WEST SUSSEX COUNTY COUNCIL CONSULTATION

TO:	Arun District Council FAO: M. Tomalova
FROM:	WSSC - Highways Authority
DATE:	16 March 2020
LOCATION:	107 Felpham Way Bognor Regis PO22 8QB
SUBJECT:	FP/258/19/PL Conversion, alteration & extension to provide 1 No. Class A1 Shop Unit, 1 No. Flexible Use Commercial Unit Use Classes A1/A2/B1/B8/D1 or Sui-Generis Beauty Therapist/Nail Bar & 3 No. Flats together with 3 No. vehicle parking spaces & secure cycle & refuse storage facilities (resubmission following FP/32/19/PL). Additional information received.
RECOMMENDATION:	No Objection

Amendments	by	Date
a	GA Plans	NJH 16.09.19
b	GA Plans	NJH 17.09.19
c	GA Plans	NJH 19.09.19
d	GA Plans	NJH 25.09.19
e	GA Plans	NJH 25.11.19
f	GA Plans	NJH 16.12.19
g	GA Plans	NJH 20.02.20
h	GA Plans	NJH 25.02.20
i	GA Plans	NJH 02.03.20

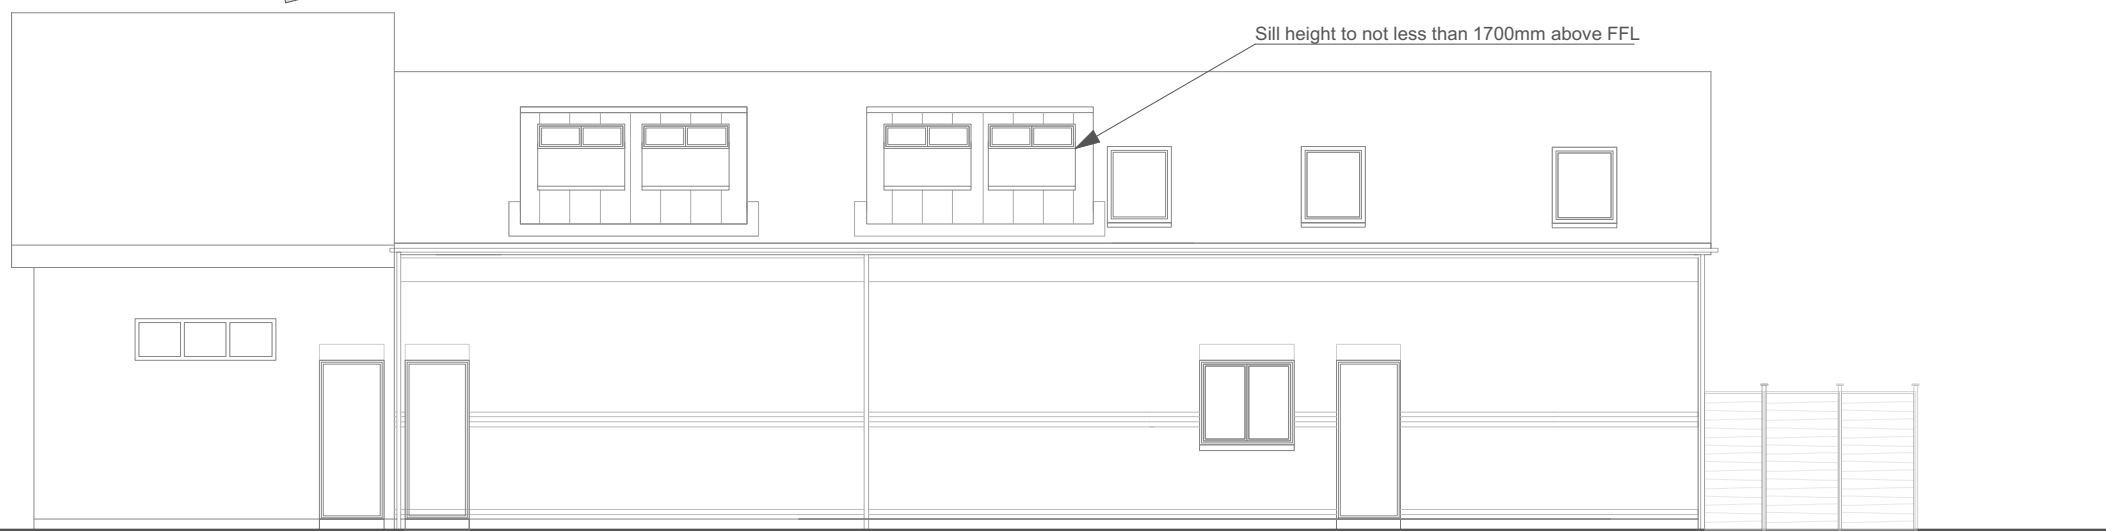
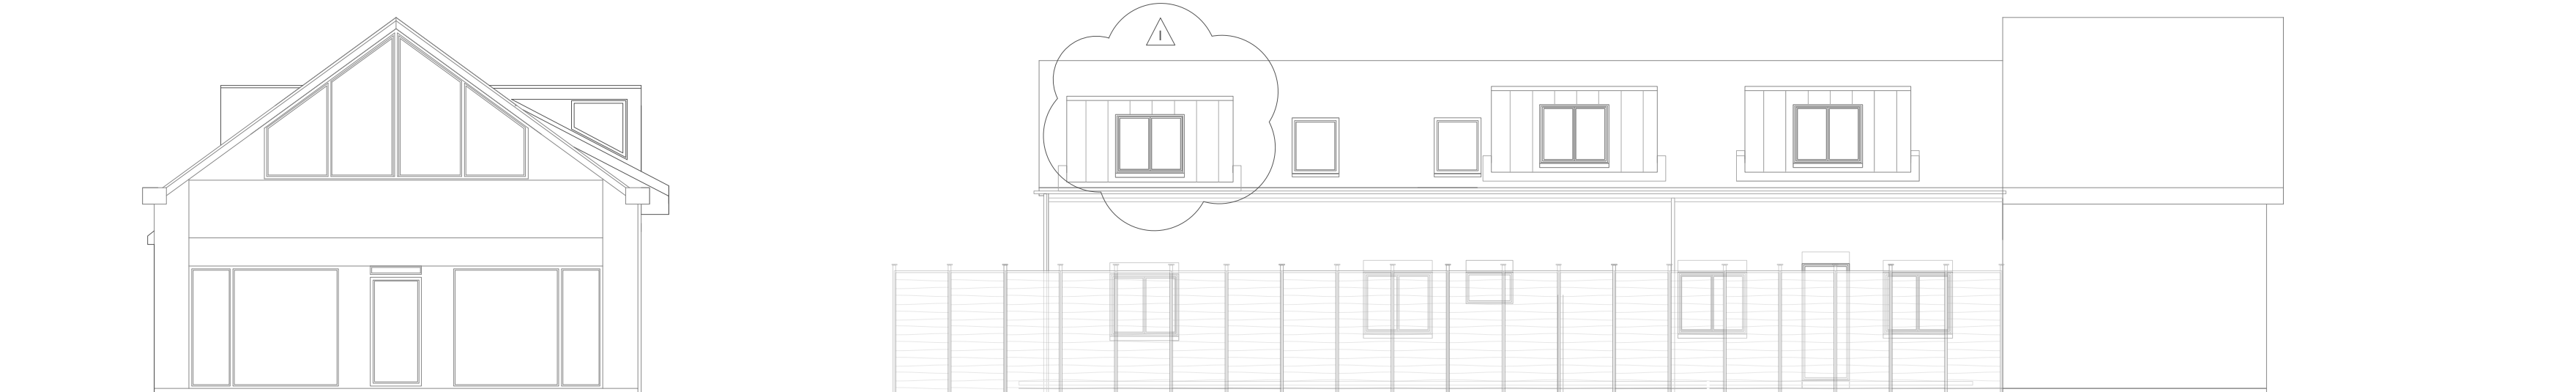
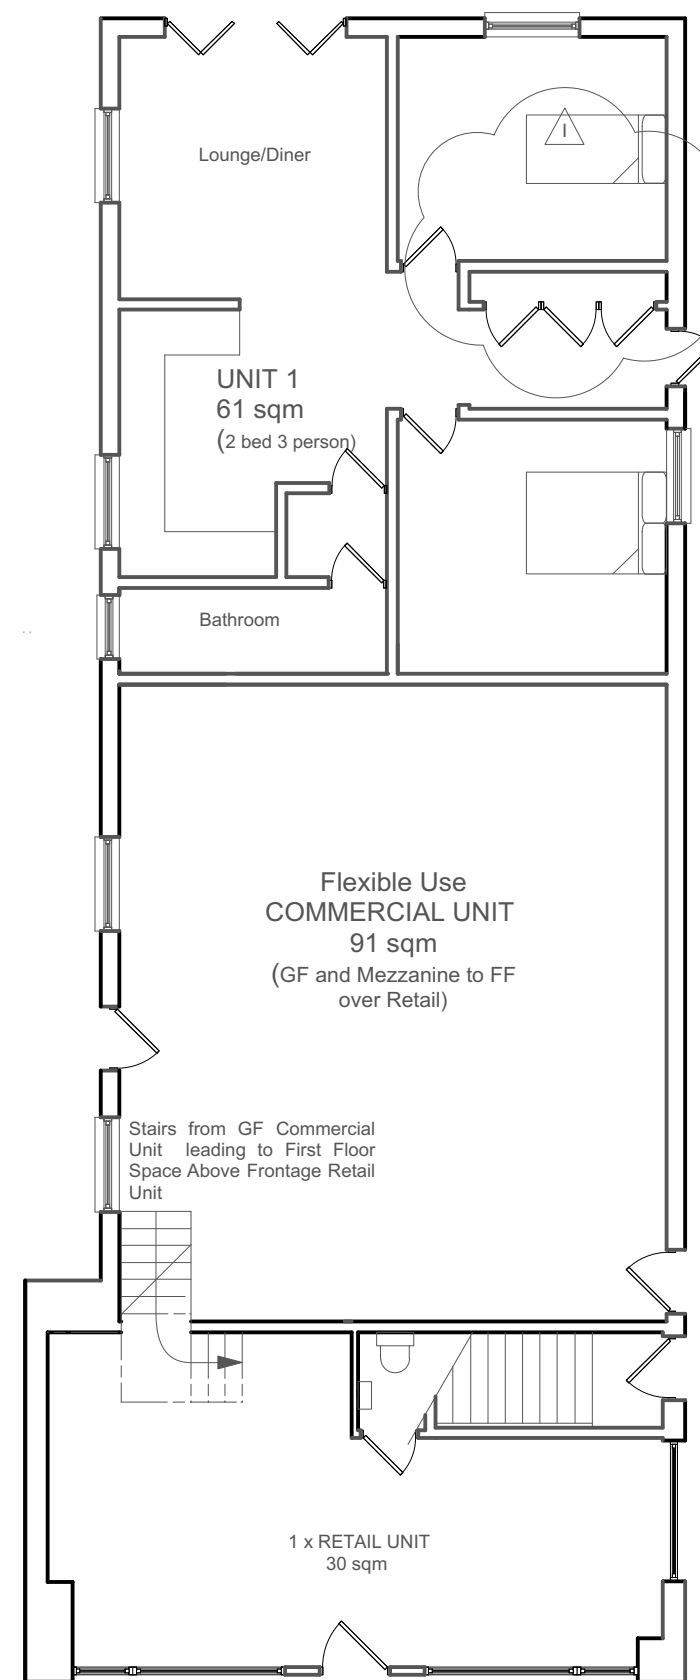
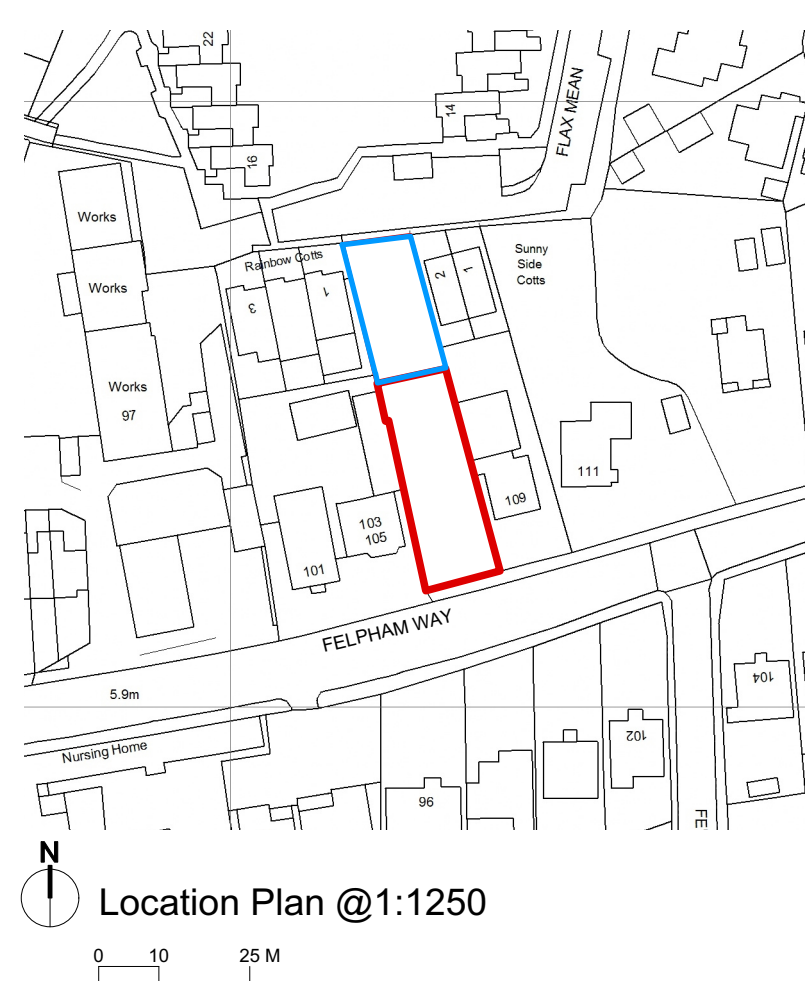
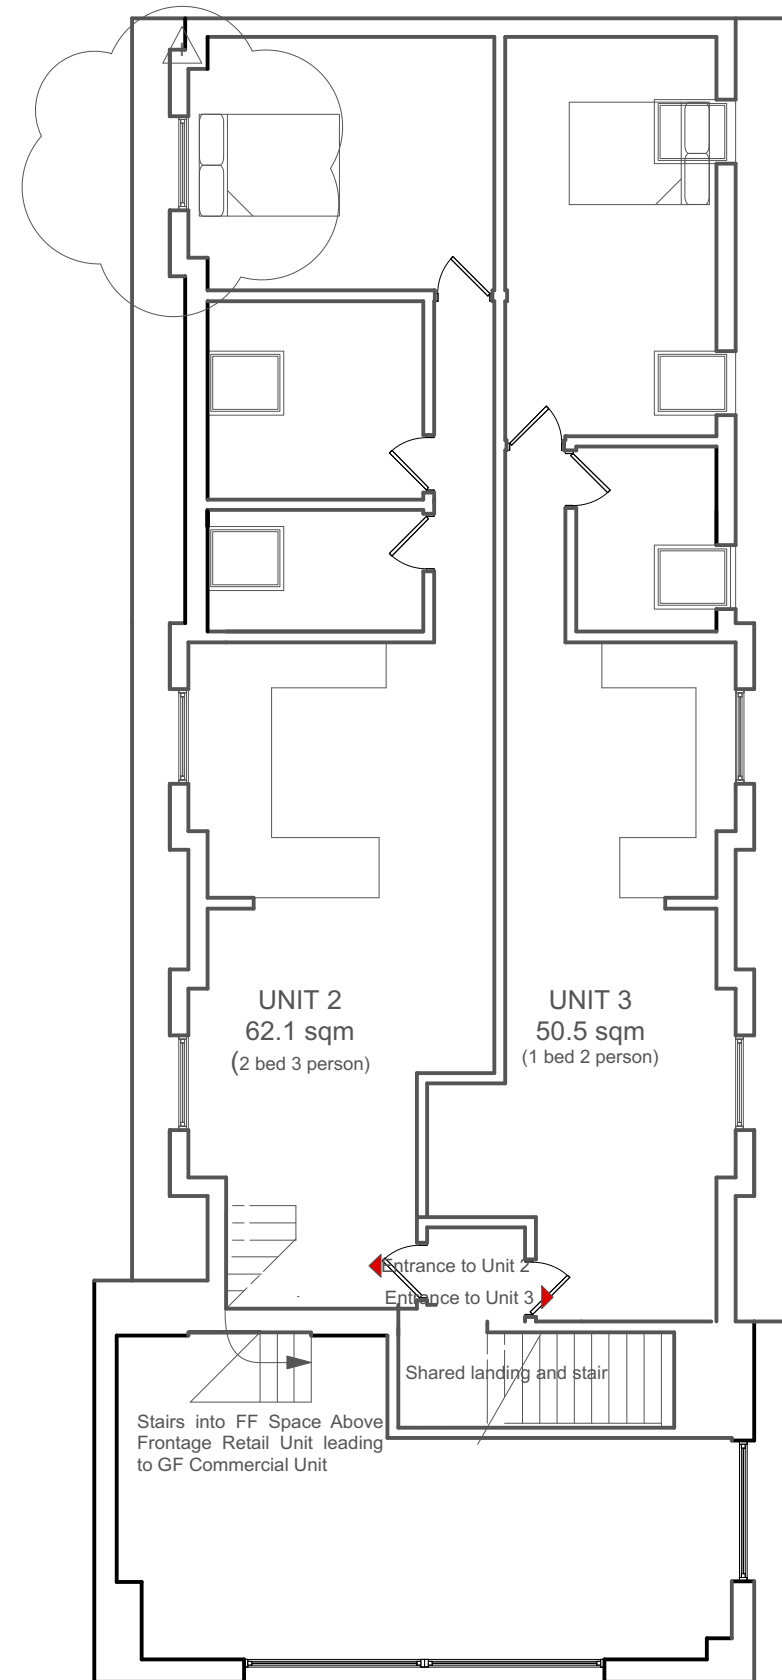
Amended plans have been received which indicate a revised arrangement of nil car parking provision on the WSSC owned forecourt. As per previous comments, a Car Parking Capacity survey was undertaken and demonstrated that an average of 81 spaces were available nearby on-street overnight. Whilst maximum parking demand for both commercial and residential element of the scheme was estimated at 15 x spaces, it is acknowledged that no increase in commercial floor space is proposed. The LHA consider that the existing arrangements and capacity on-street would be suitable to serve the development.

Considering that the existing dropped kerb provides some vehicular access to the side of the building and is not proposed to be reinstated, the applicant may wish to relocate the bicycle parking. It is advised that residential cycle parking is provided in a secure separate facility and that a small number of external spaces for the commercial element are also made available. Details of cycle parking can be secured via condition.

No part of the development shall be first occupied until covered and secure cycle parking spaces have been provided in accordance with plans and details submitted to and approved by the Local Planning Authority.
